PLANNING APPLICATION CONSULTATION RESPONSE

Application Number:	3/2023/0305
Proposal:	Proposed construction of a 68 bed residential care home, related infrastructure and landscaping.
Location:	Land at former Higher Standen Farm (adj Swardean Way Valley Lane Higher Peak Crescent South Gate Broadfield Street) Pendle Road Clitheroe BB7 1PR

The Lead Local Flood Authority **objects** to the above application on the basis of:

Objection 1 – Inadequate Surface Water Sustainable Drainage Strategy

DRAINAGE SCHEME
PROPOSED LAYOUT

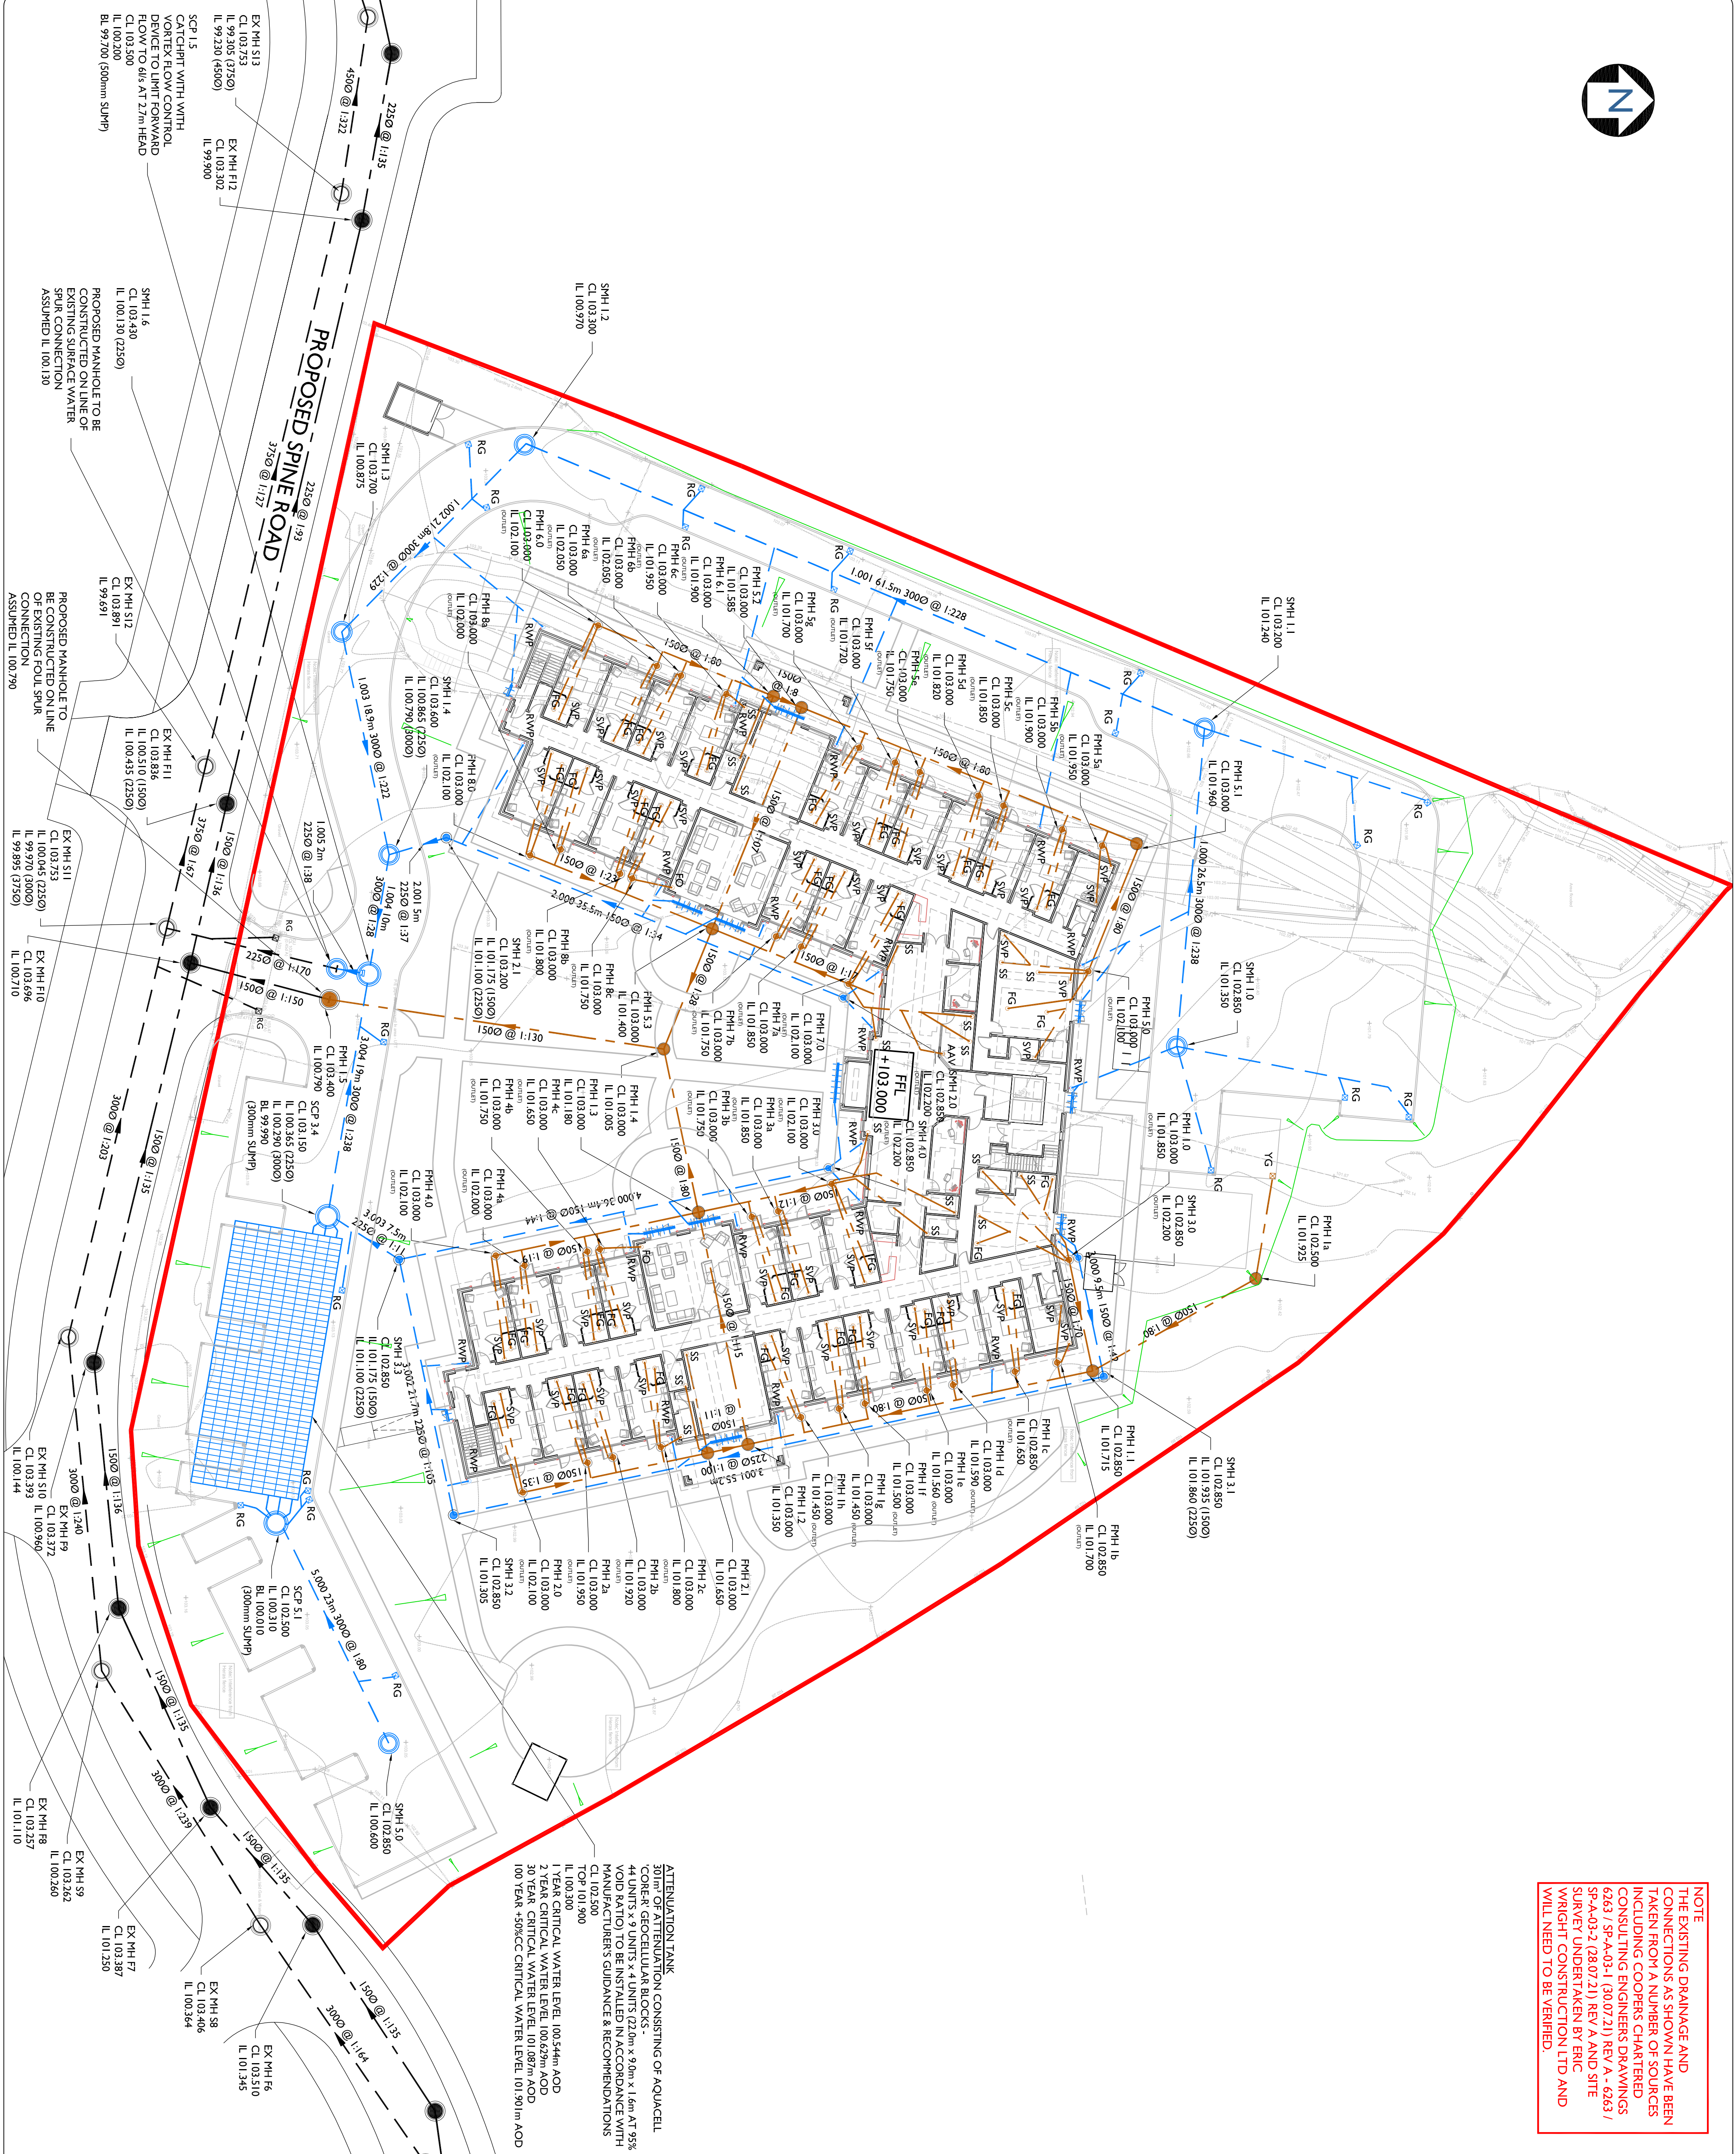
1. **Provide appropriate minimum operation standards for peak flow and volume control**, in line with the Defra Technical Standards for Sustainable Drainage Systems, therefore, is contrary to paragraph 169 of the National Planning Policy Framework.

Standard S6 of the Defra Technical Standards for Sustainable Drainage Systems requires applicants to demonstrate that post-development surface water runoff volume of any proposed development is discharged at a rate that does not adversely affect flood risk (Qbar).

The submitted surface water sustainable drainage strategy states that surface water from the site will be discharged at 11l/s but fails to demonstrate how the greenfield Qbar rate for the site has been calculated and therefore contain surface water volume flows within the parameters set out in Standard S6 of the Defra Technical Standards for Sustainable Drainage Systems as evidence. This is sufficient reason in itself for a refusal of planning permission.

2. **Provide an appropriate allowance for climate change**, in line with [national guidance](#) and, therefore, does not have appropriate minimum operation standards for the lifetime of the development, contrary to Paragraph 169 of the National Planning Policy Framework. Failure to provide an appropriate allowance for climate change will result in increased flood risk on and off site over the lifetime of the development. This is considered contrary to Paragraph 167 of the National Planning Policy Framework and therefore sufficient reason in itself for a refusal of planning permission.

The applicant has failed to provide evidence of an urban creep allowance being applied to the development.

You can overcome our objection by submitting information that covers the deficiencies highlighted above and demonstrates how surface water will be managed on-site, to satisfy Paragraphs 167 and 169 of the National Planning Policy Framework, the Planning Practice Guidance, and the Defra Technical Standards for Sustainable Drainage Systems.

The Lead Local Flood Authority asks to be re-consulted with the results of the amended site-specific flood risk assessment and/or amended sustainable drainage strategy and/or SuDS Pro-forma. We will provide you with further comments within 21 days of receiving formal re-consultation. Re-consultations should be sent to our identified mailbox.
